Consultation Response from KC, Conservation & Design**2023/92033 Hoyle Ing Dyeworks Former, Hoyle Ing, Linthwaite, Huddersfield, HD7 5QS****Erection of 6 bungalows with ancillary staff area (within a Conservation Area)****Date Responded: 28.9.2023****Responding Officer: Sue Brooks****Responding Ref:**

1.5m high close boarded timber Bin Store unit - 1-100

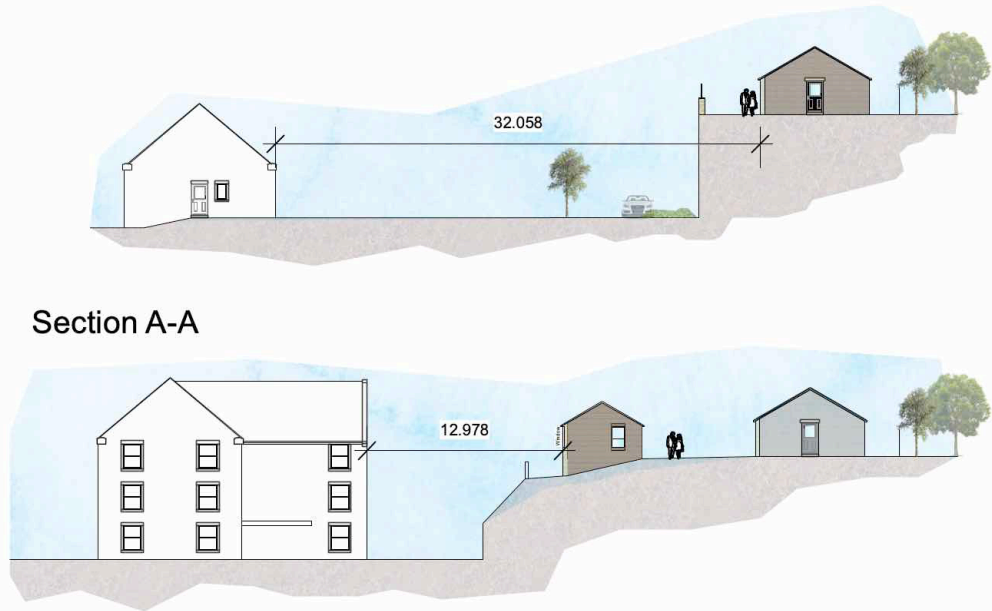
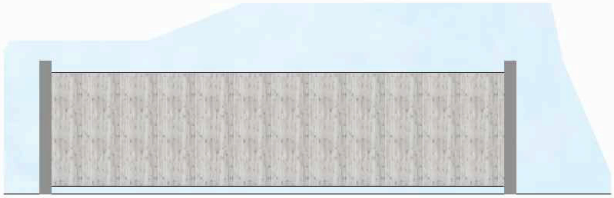
- Details of the boundary treatments and bin stores should be submitted, this can be by condition.

NW Elevation

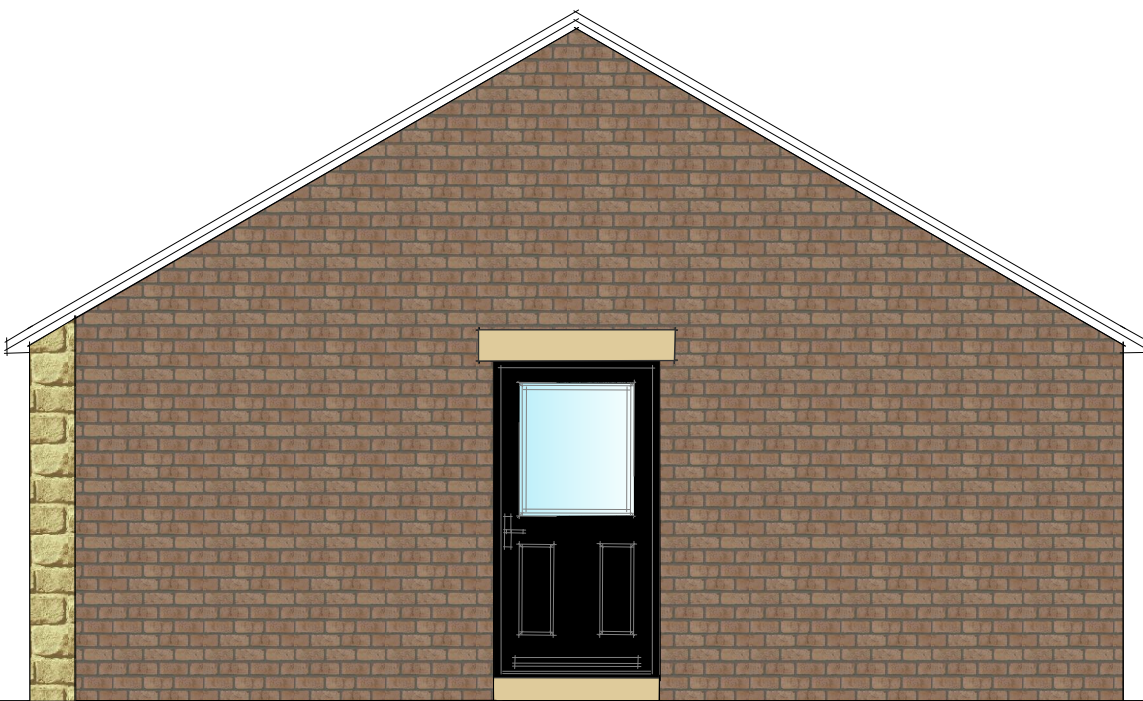
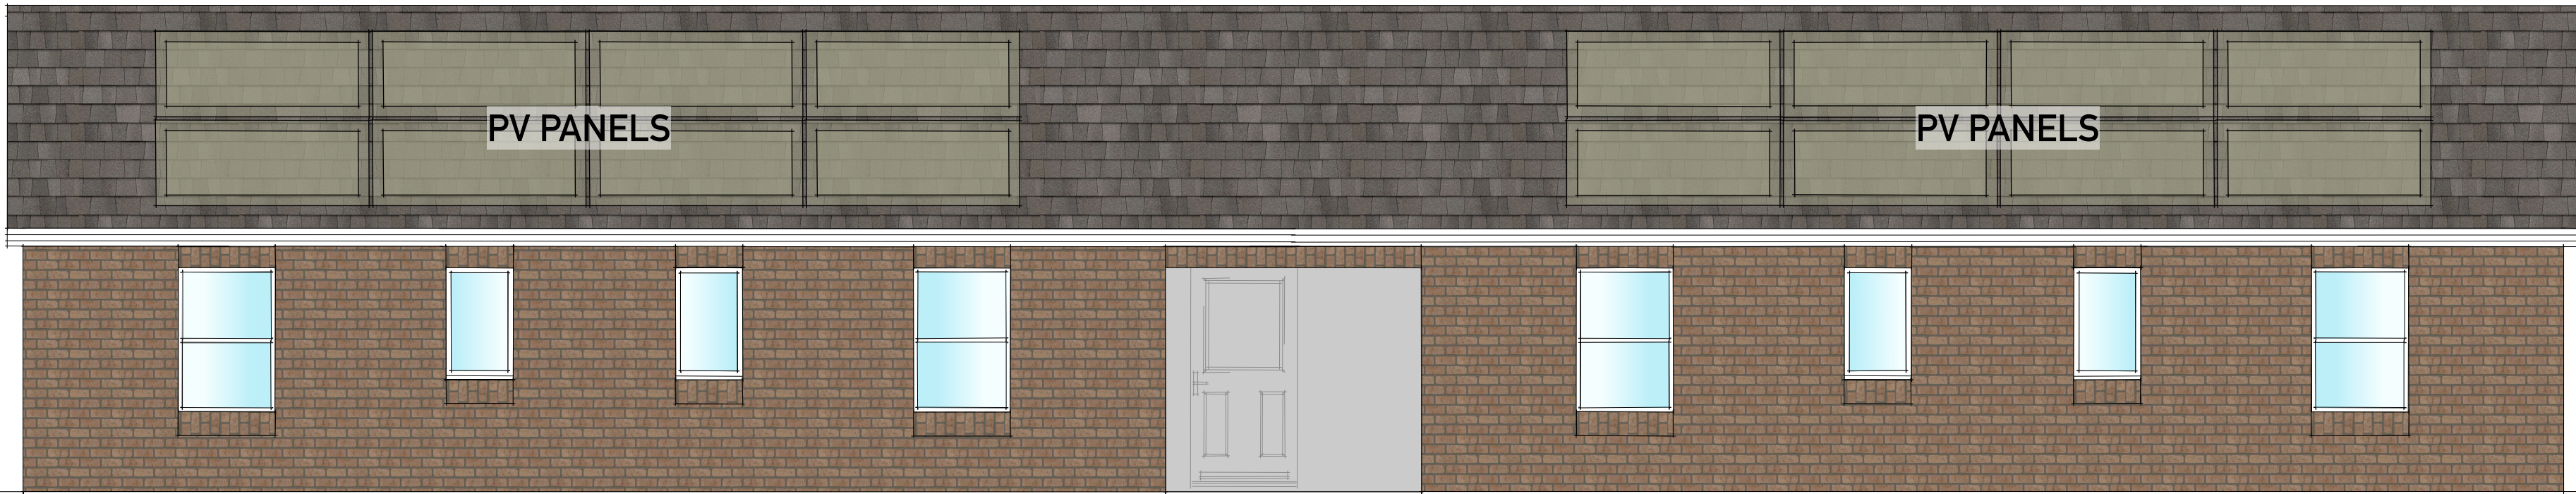
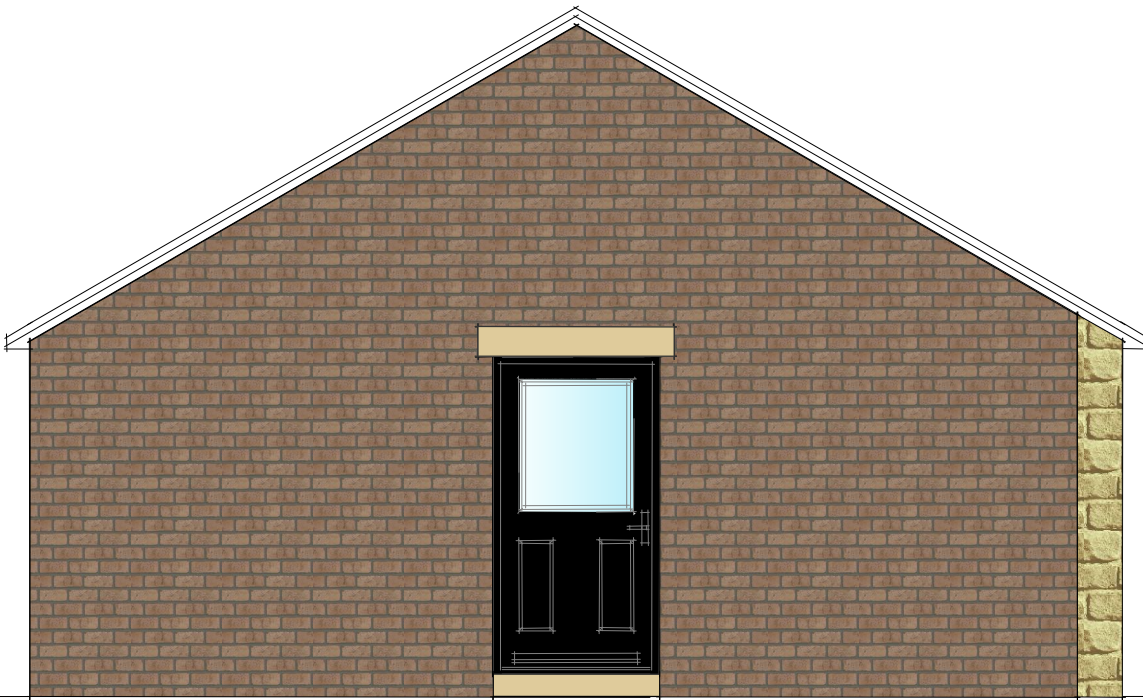
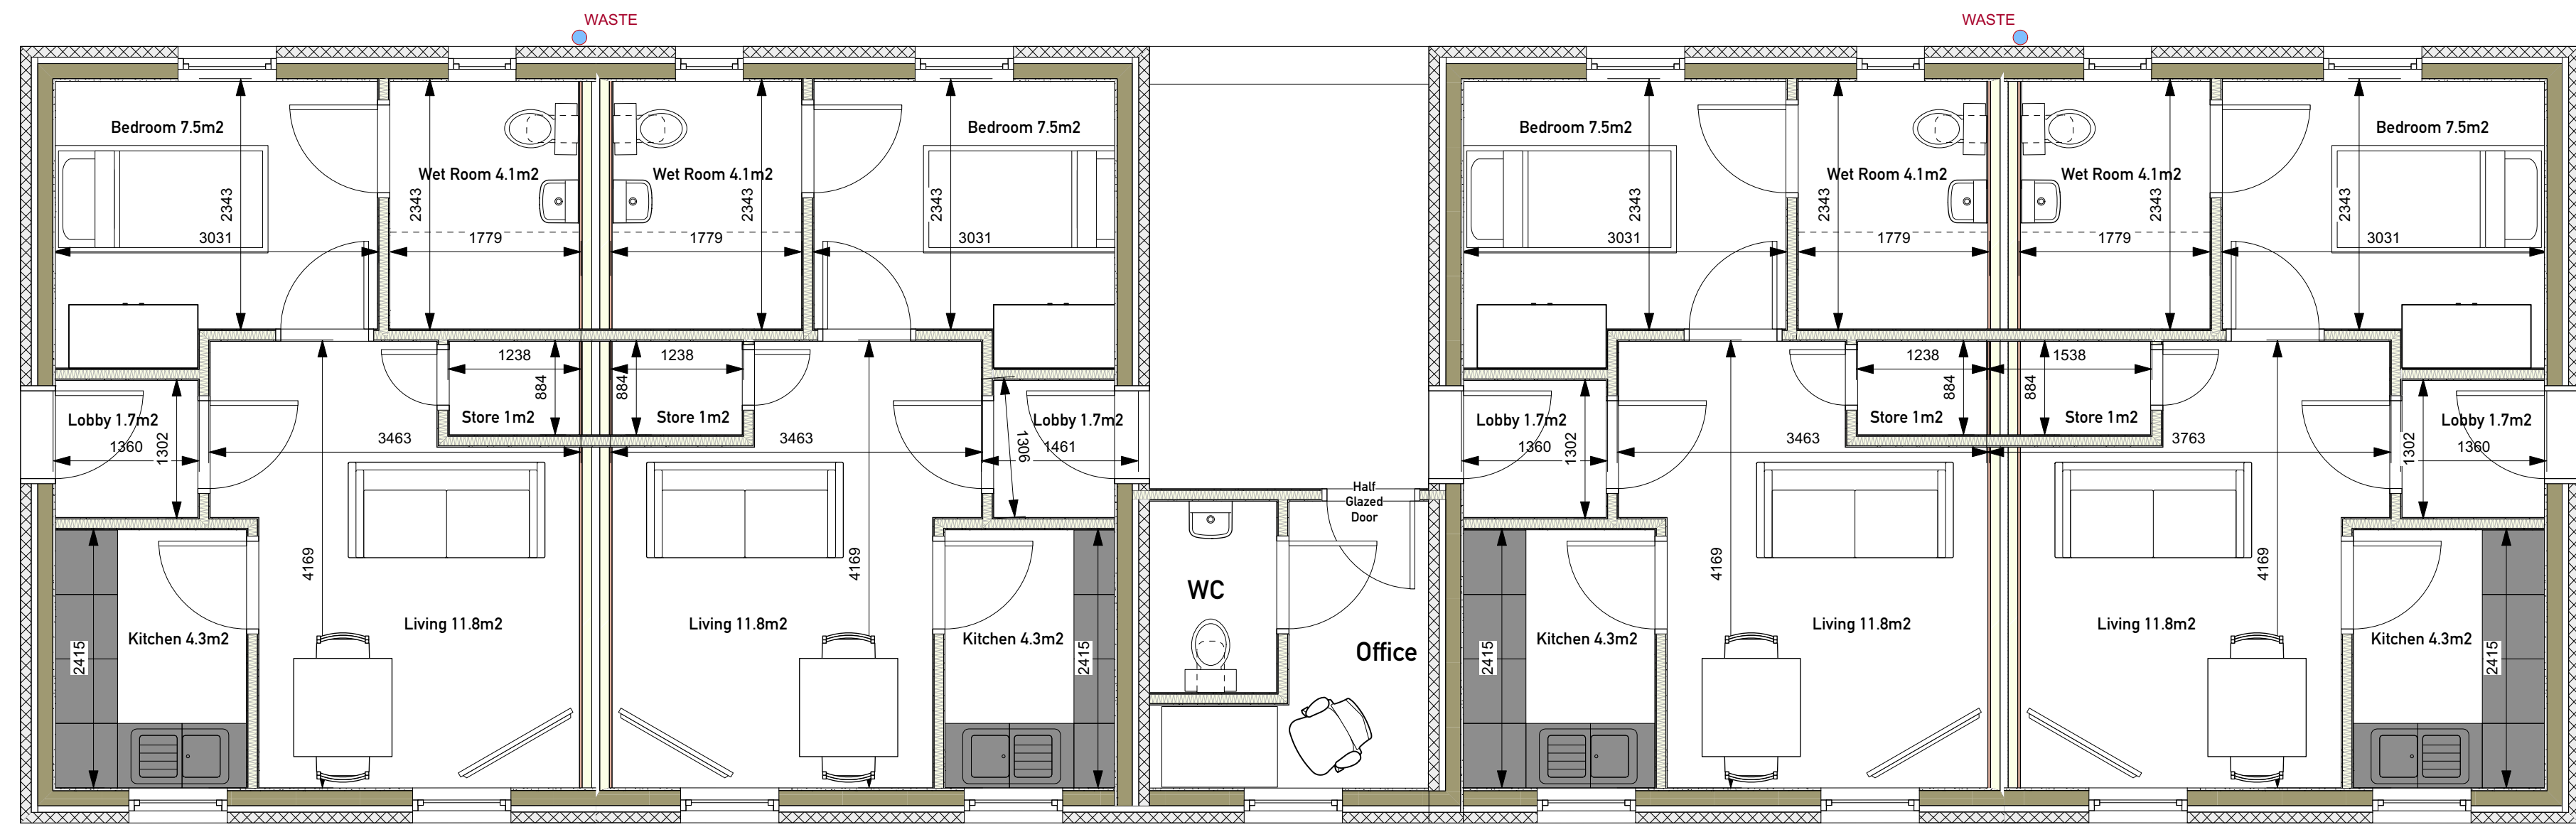
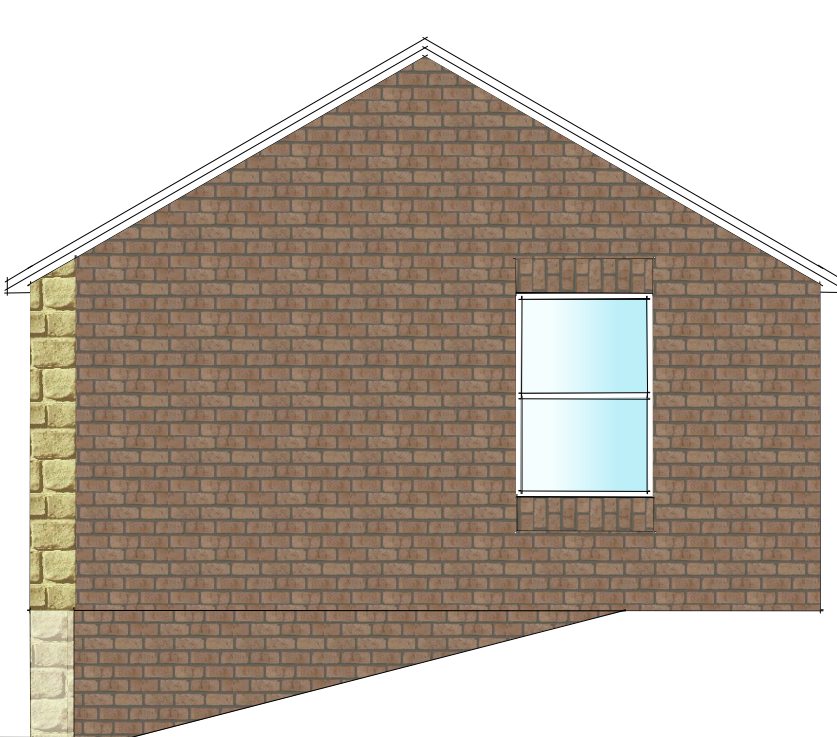
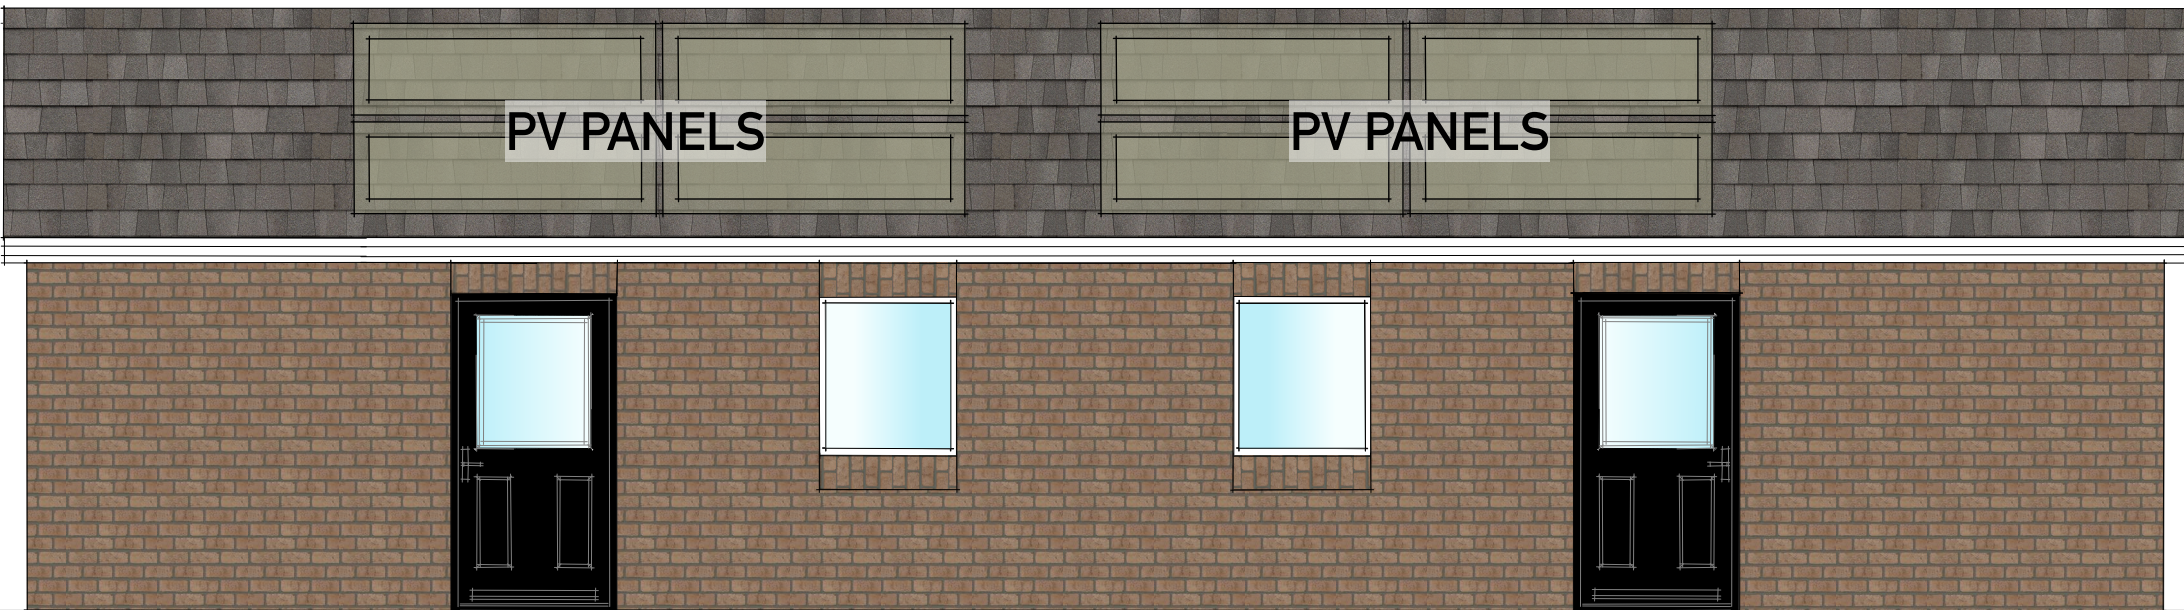
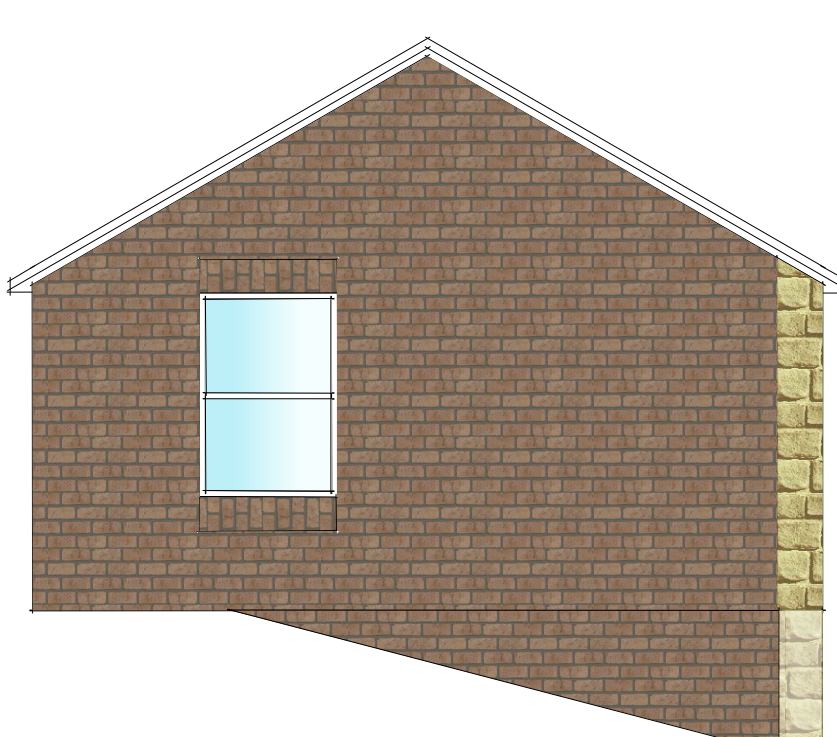
- The external masonry for the north-west elevations of both bungalows has been amended to stone on the proposed elevation drawings. We would recommend that a condition is applied to ensure that natural stone is used to match the type and coursing of the Phase 1 bungalows.
- As there is still very little external detailing and articulation on the prominent north-west elevation, we would suggest that stone gutter corbels are incorporated into the design.
